Rezoning Petition Review

Rezoning Petition #: 20-140

Location of Property: Approximately 0.53 acres located in the southeast quadrant of the intersection of Zebulon Ave and Rozzelles Ferry Rd and west of Trade St.

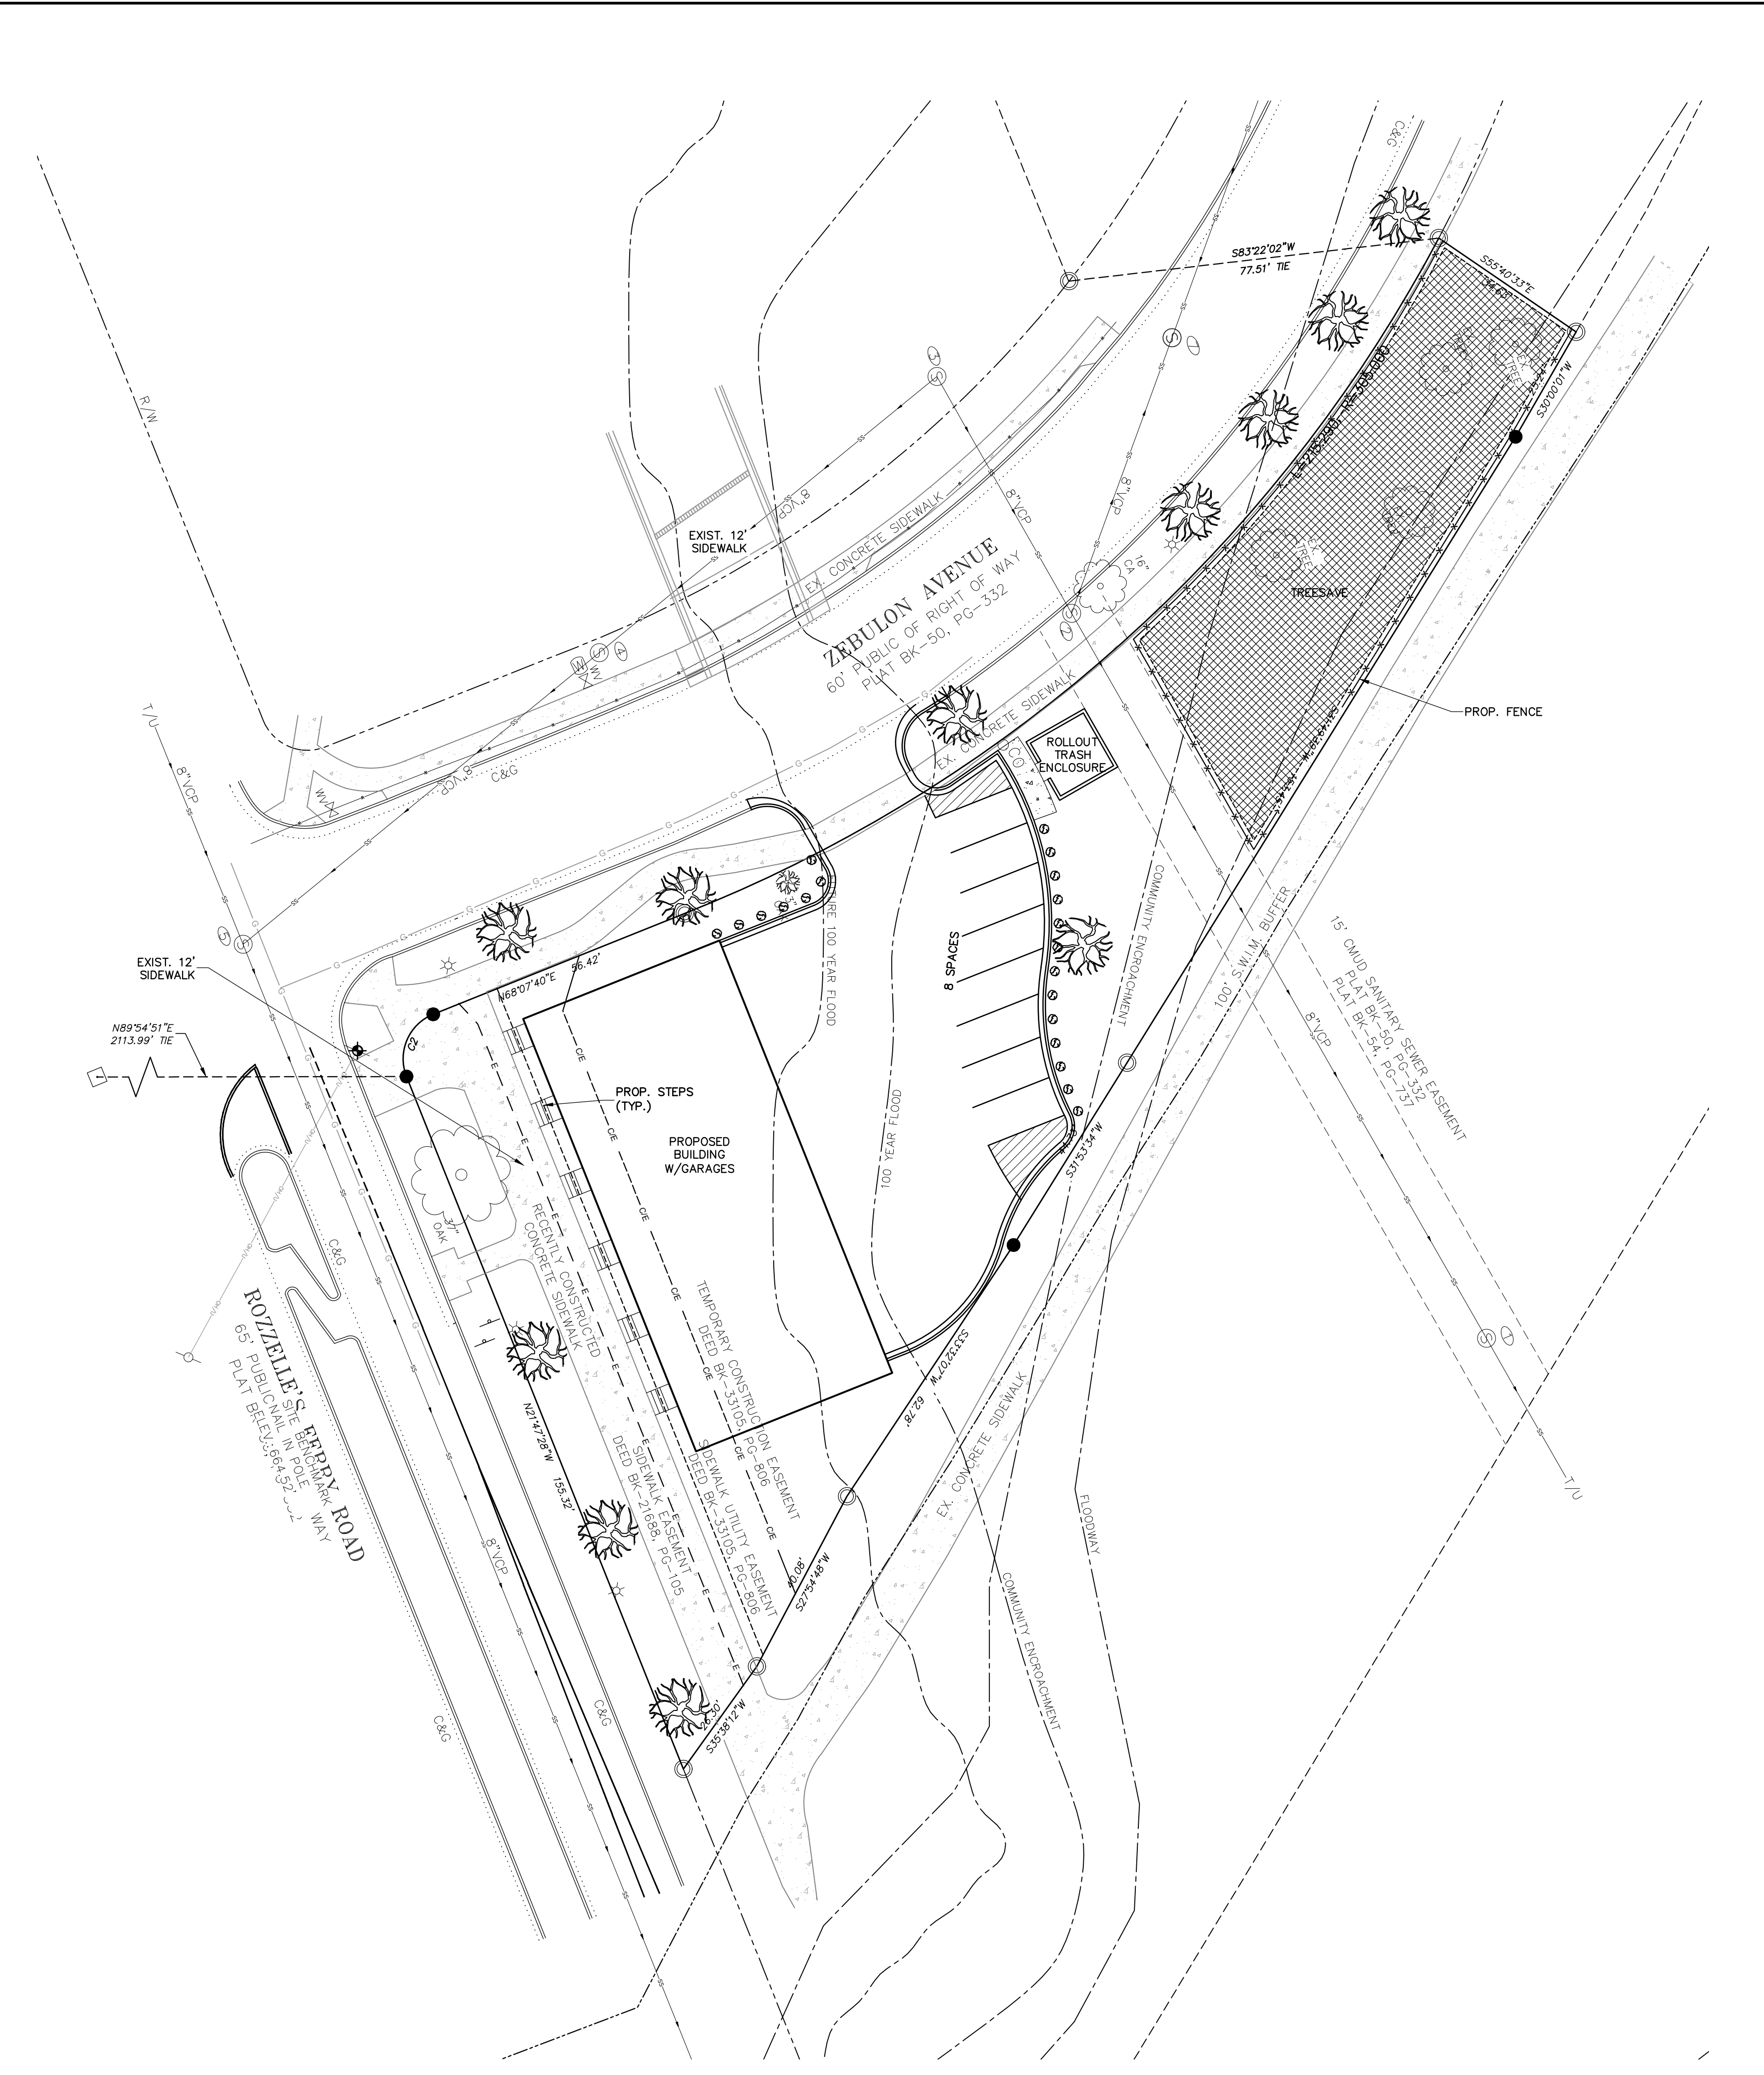
Please remove the second sentence under "Environmental Features" in its entirety. The use of existing BMP/SCMs are not approved through the rezoning process and are part of the formal plan submittal and review process.

Petitioner is advised the 100' SWIM/PCSO Stream Buffers on the site may require the inclusion of 50% of the flood fringe area as additional stream buffer. Delineation of the additional stream buffer area may be deferred to the permitting process and is not required to be shown on the rezoning plan.

Please include the following notes on the plan sheet under "Environmental Features":

- *Development within any SWIM/PCSO Buffer shall be coordinated with and subject to approval by Charlotte-Mecklenburg Storm Water Services and mitigated if required by City ordinance. Petitioner acknowledges intermittent/perennial stream delineation reports are subject to review and approval upon submission of development plans for permitting and are not approved with rezoning decisions.*
